Good morning Emma,

The following comments are made in relation to MOD14 at Huntlee.

LARGE LOT RESIDENTIAL
SCALE 1:3500

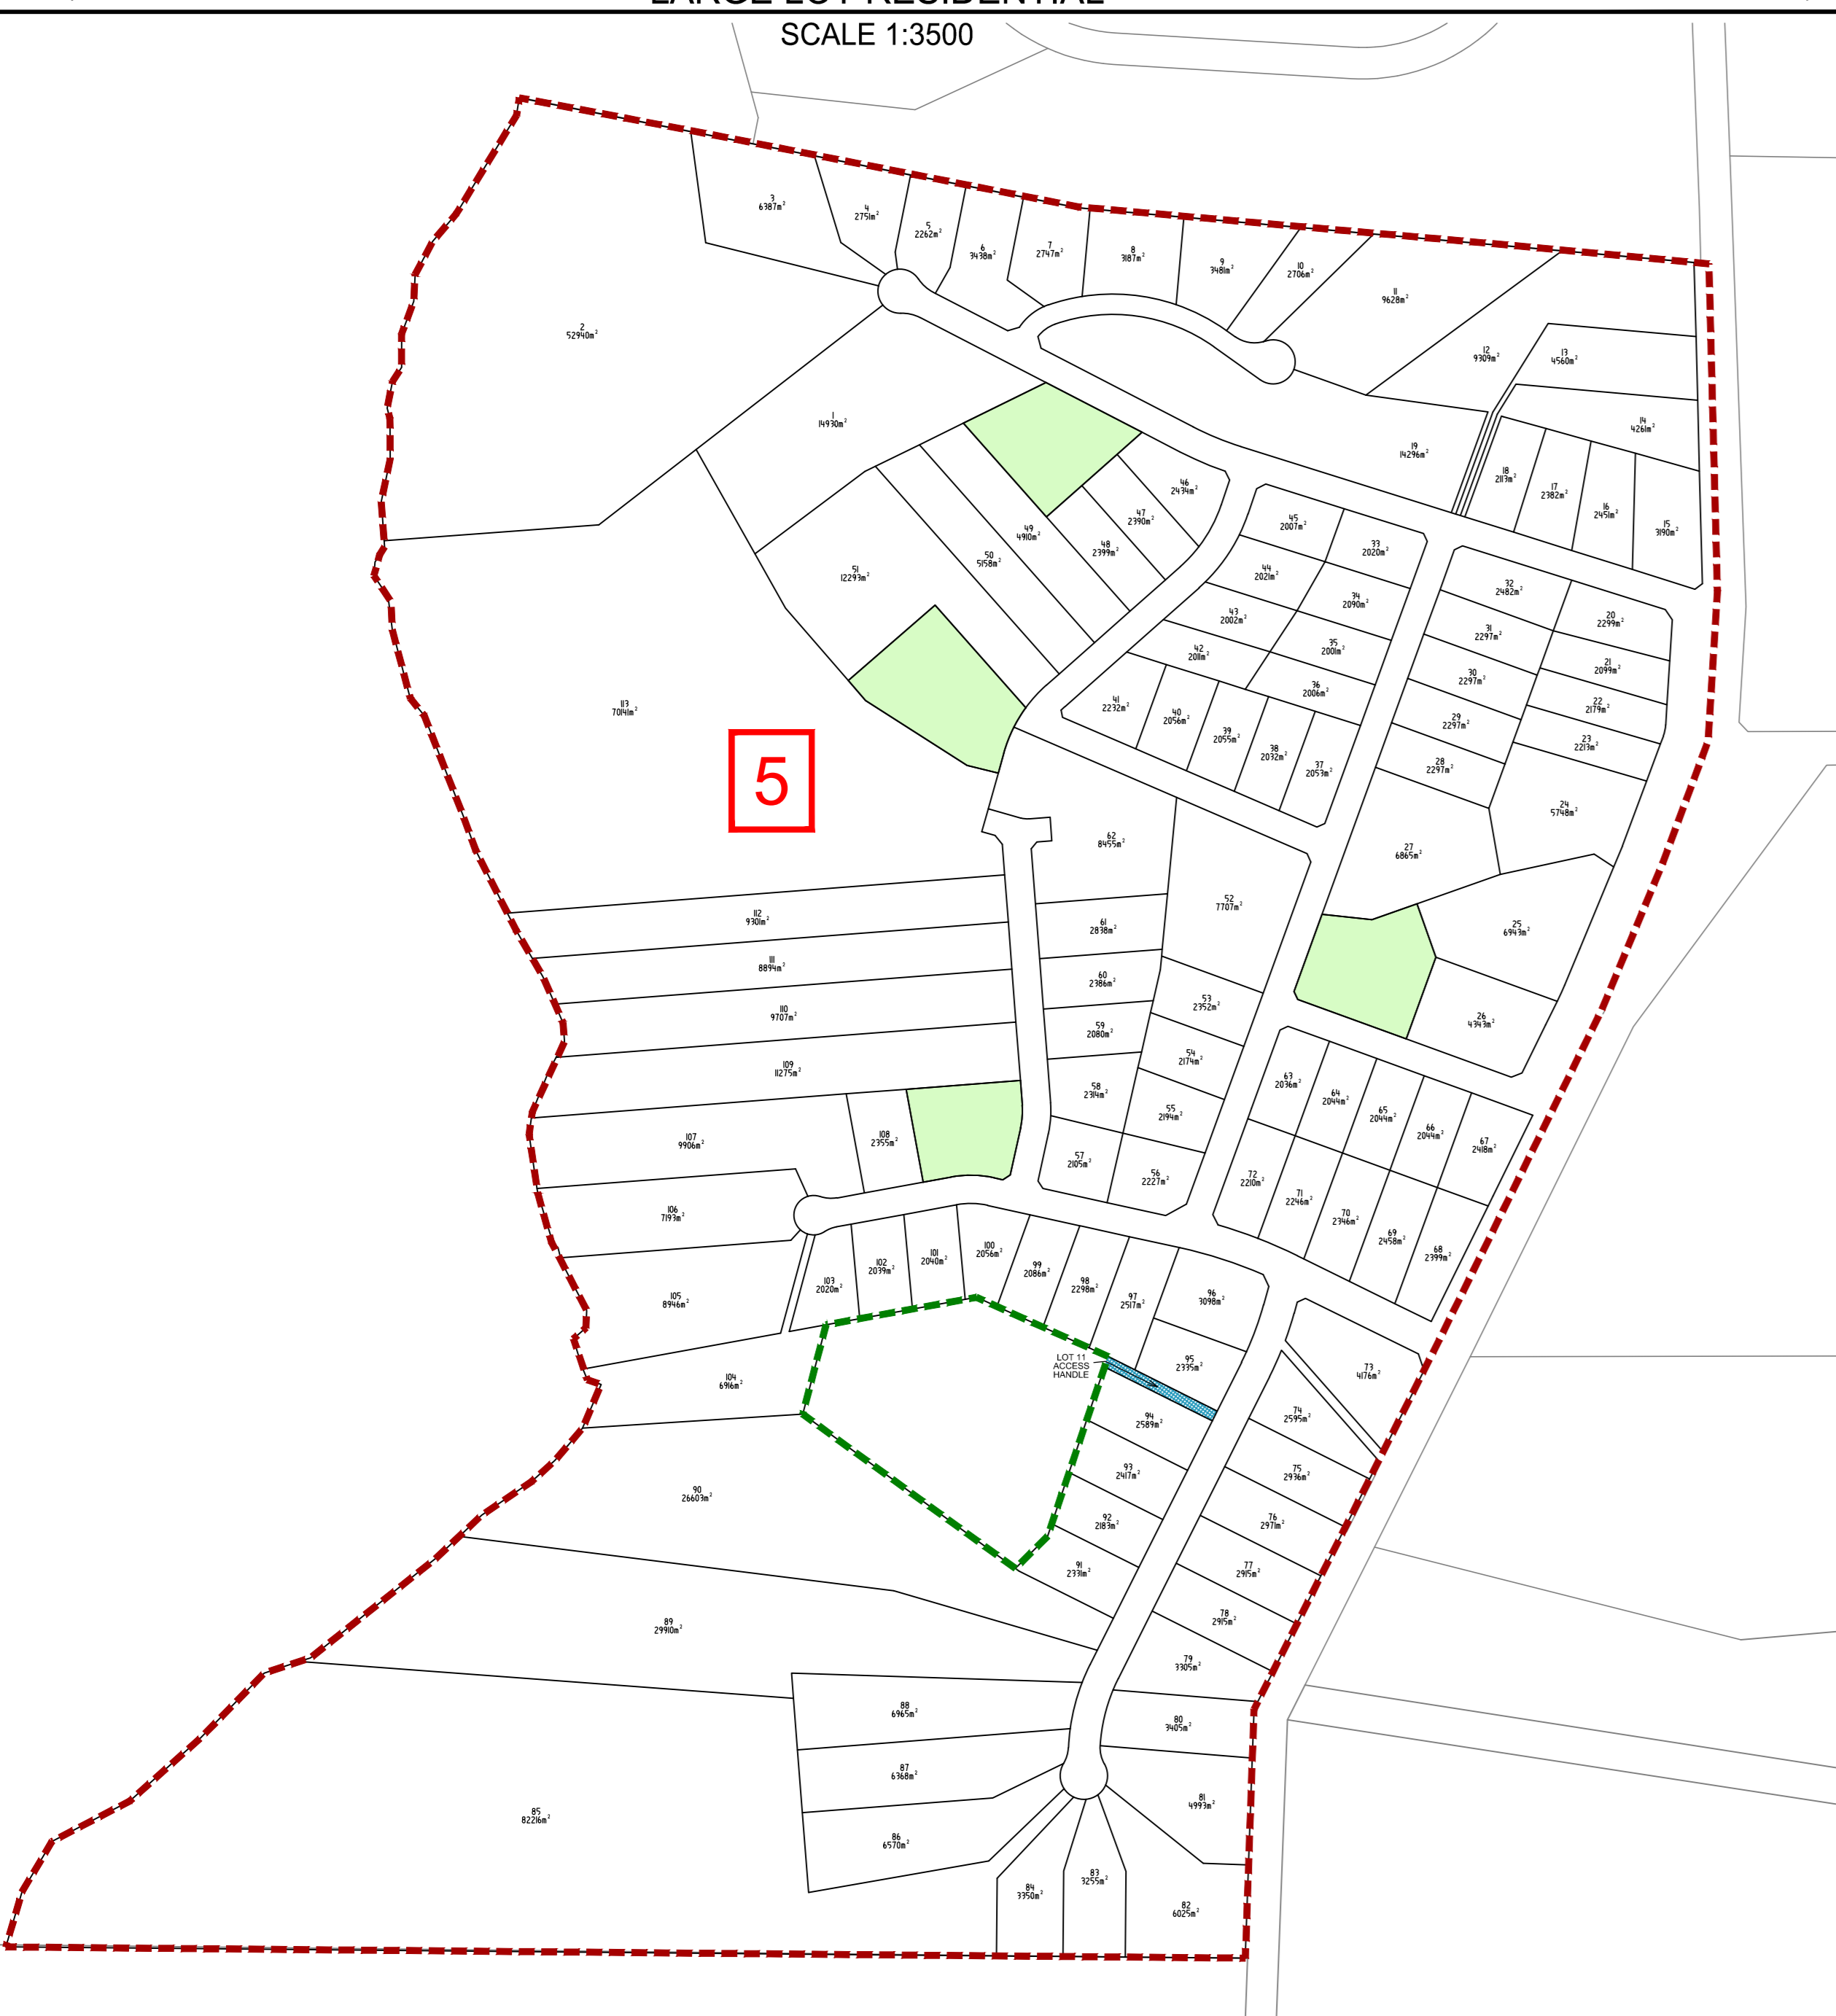
- Identification of a building envelope on the DP and 88b for each allotment. The building envelope for each allotment should be sited within the existing cleared area of each allotment, where possible.

Council PMF Flood Depth and Extent

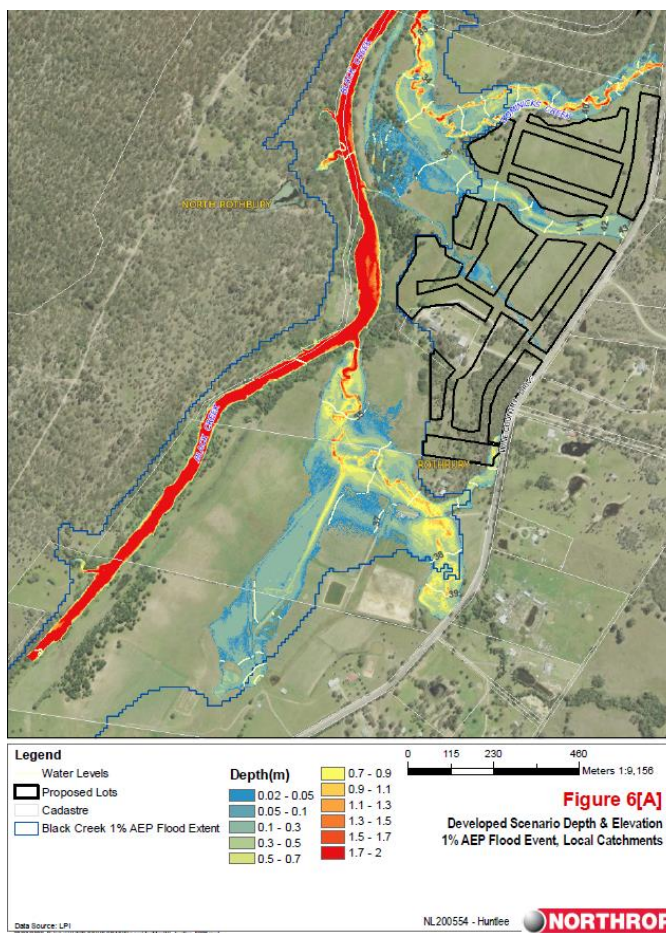
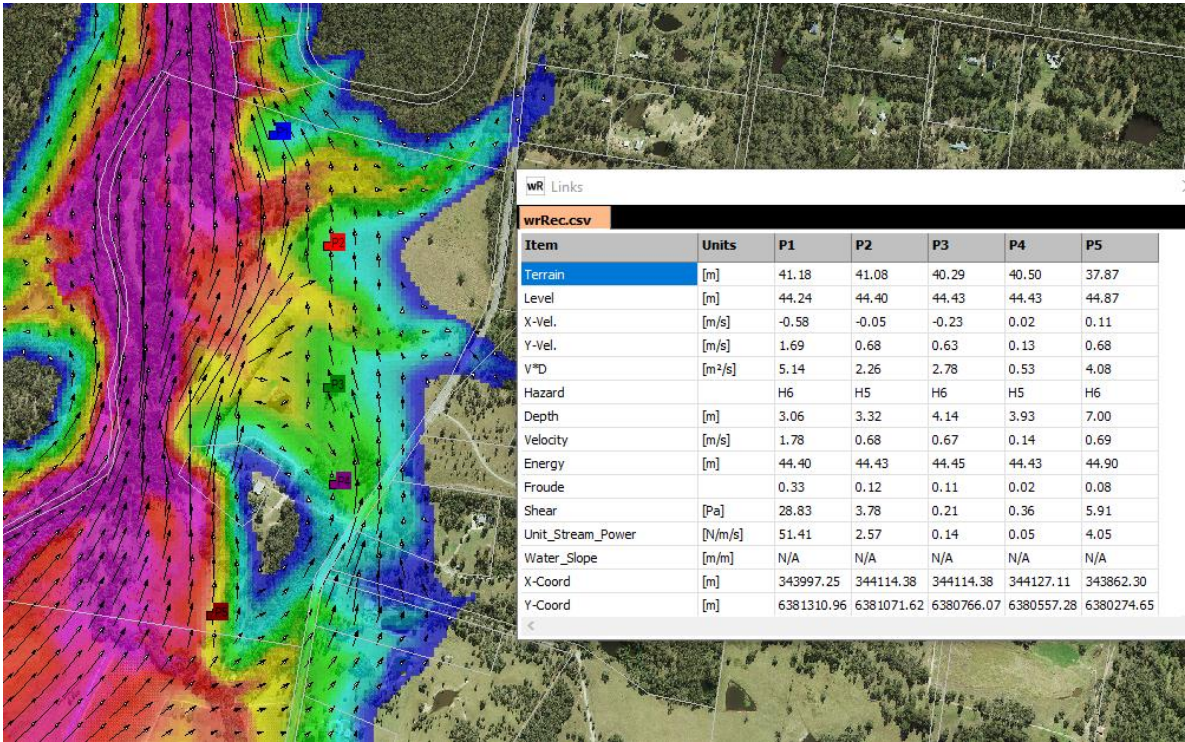
- Concerns in raised in relation to flood risk of flood events rarer than the 1% AEP (100yr ARI) flood.
- The Black Creek Stage 2 flood model shows flood depths in this subdivision of up to 7m with the majority of the site experiencing H6 flood hazard. What this means is that an event similar to a PMF could result in loss of life and serious structural damage of buildings and infrastructure.
- The response received is shown below and is extracted from page 27 Stormwater Management Strategy for Wine Country Drive Large Lot Residential Subdivision, Northrop April 2021:

During the regional PMF event, the subject site is expected to be affected by up to approximately 7 meters of flood water over the developable portions of the site. It is anticipated that given the magnitude of the event, enough notice will be available for future residents to evacuate prior to the peak of the event. This is expected to be addressed in a regional flood emergency plan.

- This response assumes that flood risk can be adequately managed in a regional flood emergency plan. It is likely that the only reliable method to manage this risk will be the installation of a flood warning system. This system should be paid for by the proponent, as there is no existing residential zoned nearby that would benefit from a flood warning system.
- In addition it is requested that LWP prepared flood mapping for the 0.5% AEP (200yr) and 0.2% AEP (500yr) which show flood risk and demonstrate flood free evacuation routes for all residents.
